**RFI**

RFI #: 31  
 Date: 1/10/2012  
 Job: EB-02 Keller Springs Lofts  
 Phone: 877-777-5115

CC: Jordan & Skala Engineers, Inc. (Dallas)  
 Subject: Detail for 12 sleeve penetration and elevation

Subject: Purposed relocation of oil Separator  
 Drawing: P-3.0D  
 Cost Impact: None  
 Spec Section:  
 Schedule Impact: None

SHEET NUMBER
S2.14P

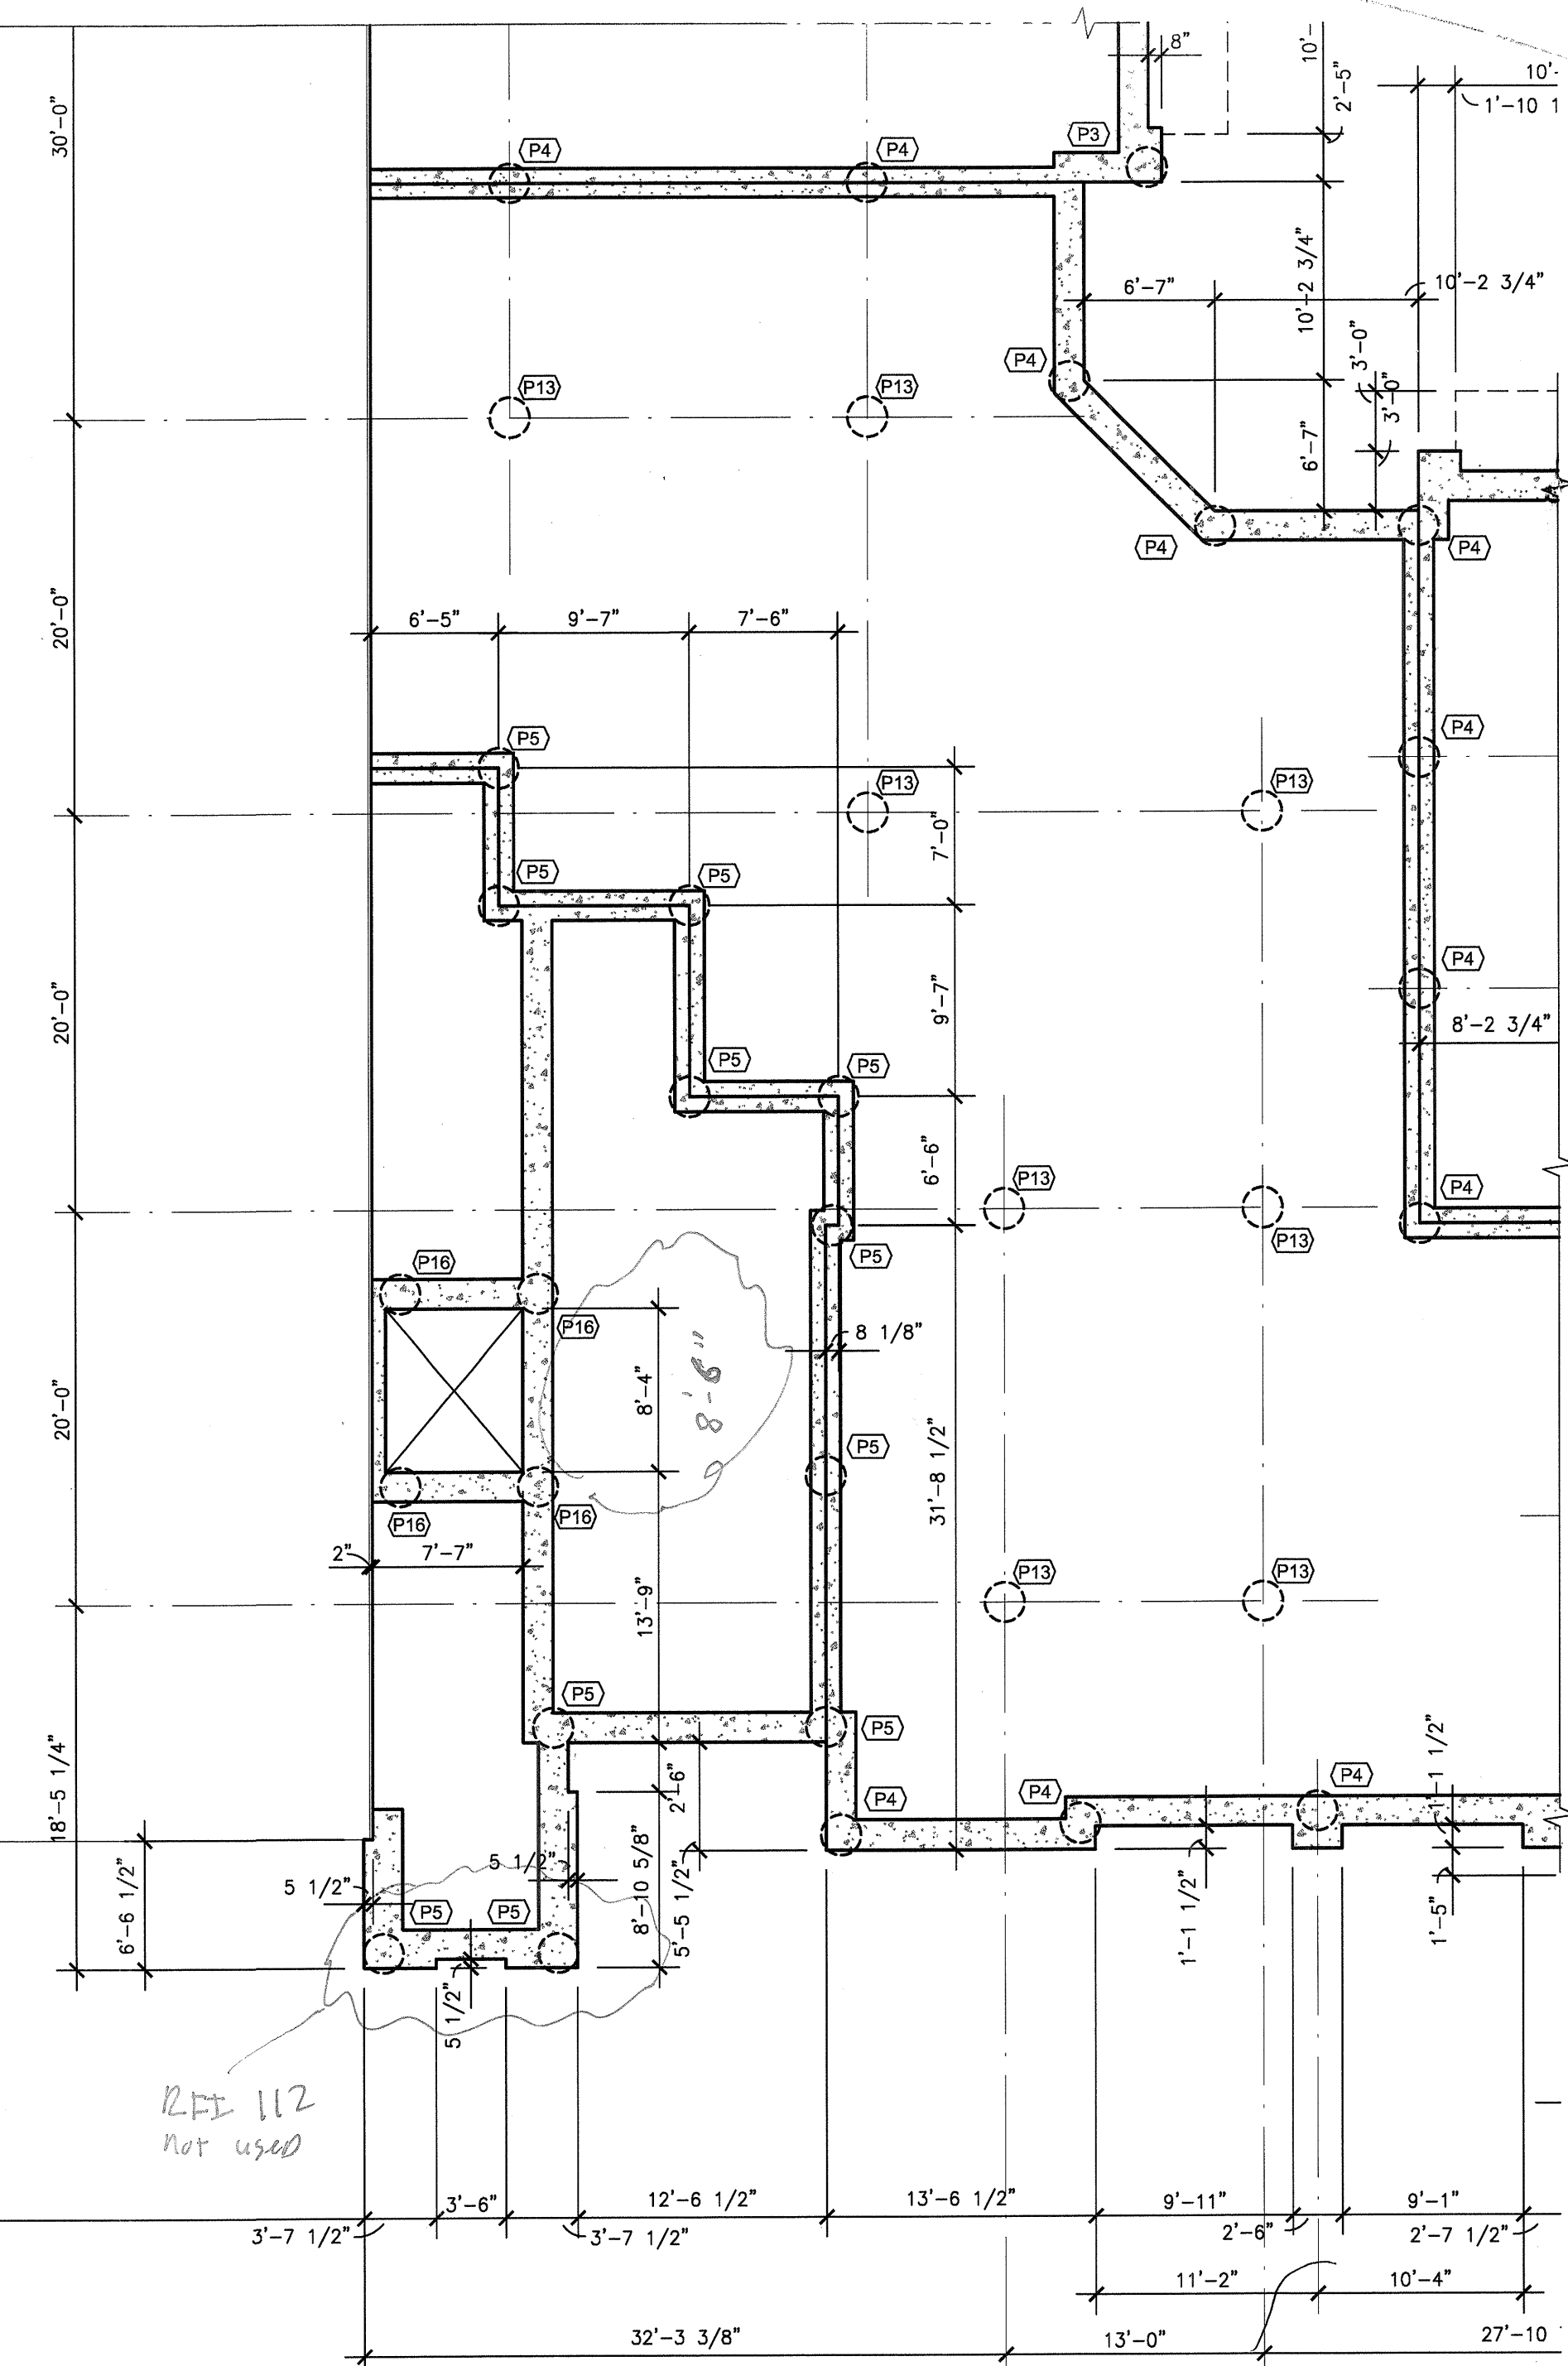
**Request:**  
 Trent we need a detail for (2) 12" drain sleeves that penetrate the southern beam wall of the garage Ref P 3.0D attached.  
 The structural engineer wants sleeves in the middle third of the beam wall. Top of Beam Wall = 639'-7 1/4" and beam is 4' deep 637'-7 1/4". Middle of the beam = 637'-7 1/4" - 6" (1/2 x 12") = 637'-1 1/4". So the bottom of the two 12" sleeves should be at 637'-1 1/4" or 637.10. This should give us plenty of fall as the original flow line of the 15" on C8 was 636.22 just inside the building. Ref C8. Can both PPO and Jordan & Skala concur and reflect it on their plans and detail?

**Response:**  
 Please see attached for a grade beam penetration detail that will accommodate the above mentioned 12 inch diameter penetrations. If the center line of either of the penetrations is closer than 2'-6" to grid line B, notify PPO for an alternate solution.  
 If you have questions or require additional information regarding this matter, please do not hesitate to contact us.
